Application No: BR/44/21/PDH
Site Address: 38 Havelock Road Bognor Regis PO21 2HA
Description of works: Notification under extended permitted development rights for a single storey rear extension with mono-pitch roof & roof lantern measuring 8m from beyond the rear wall of the original dwelling house, with a maximum height of 3.8m and eaves height of 3m

Thank you for your internet representation made on 12th March 2021 which has been recorded as an objection with the comments as follows:

Proposed Ground Floor Plan 1:50

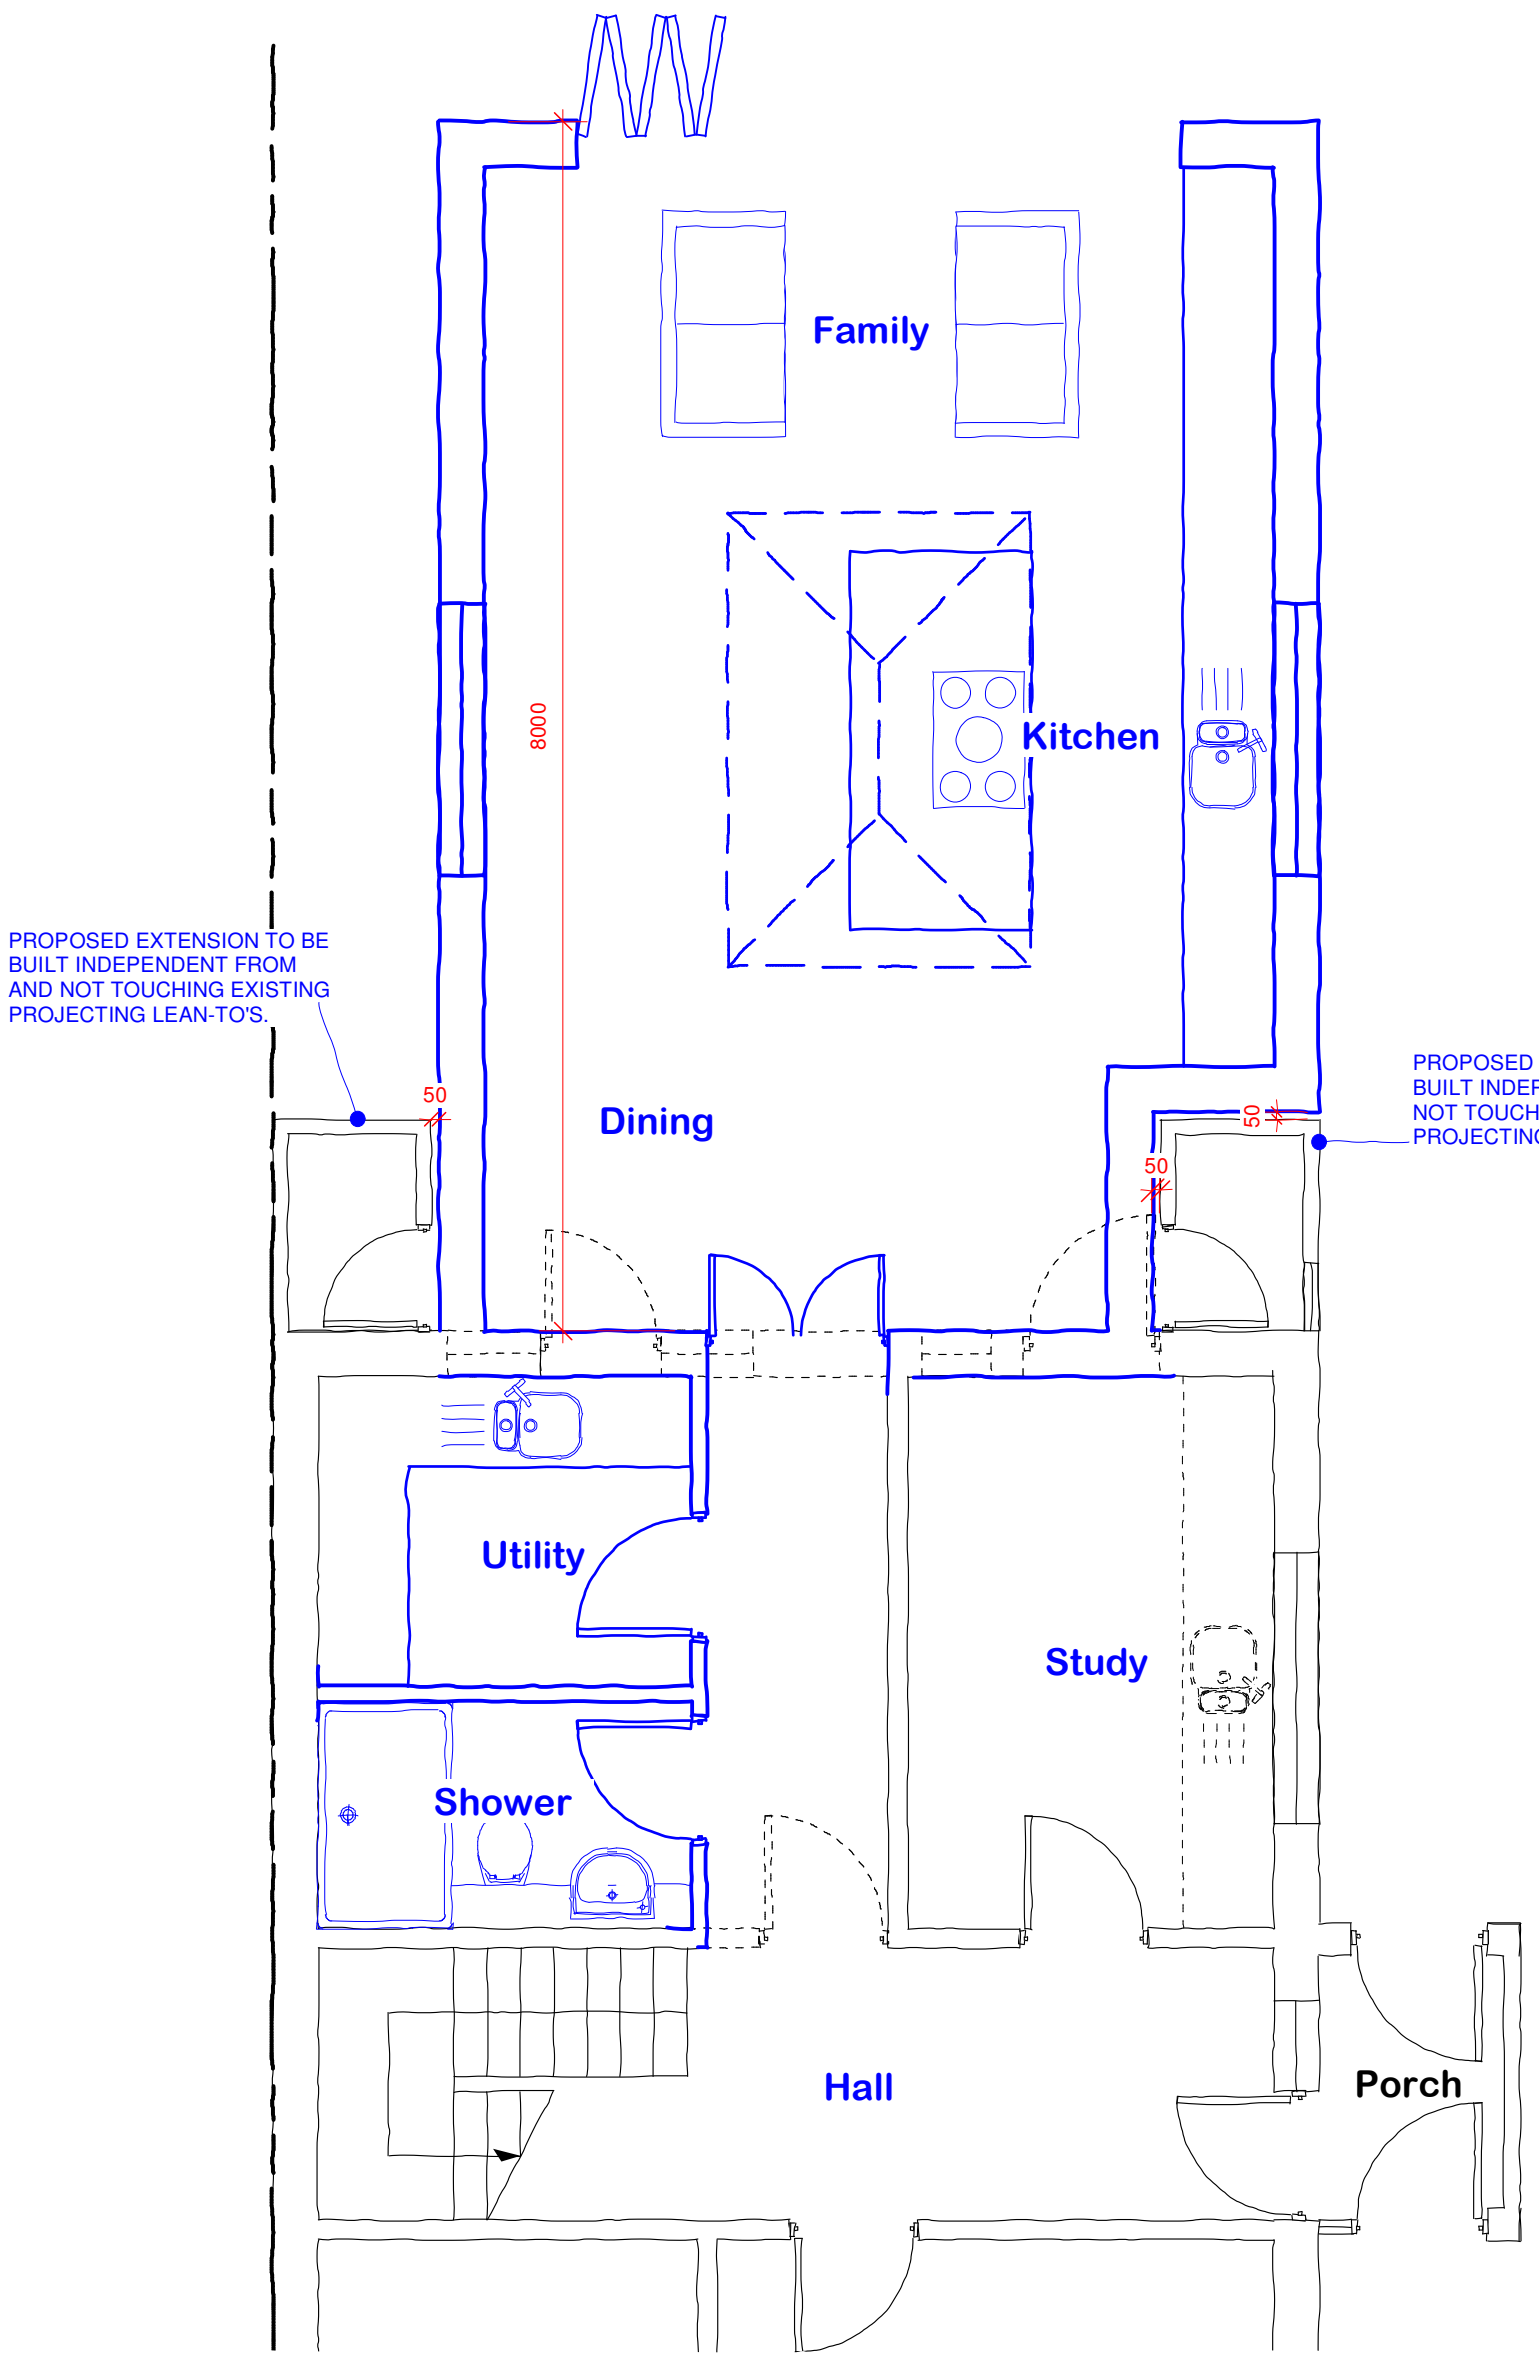
The properties/plots in Havelock Rd 34,36,38 are long and narrow.
A smaller extension was approved at no 34. This proposed 8m extension at no 38, effectively creates a tunnel effect for the small bungalow at No36. This may have a detrimental impact on the value of the plot at no 36 Havelock Rd in its current condition.
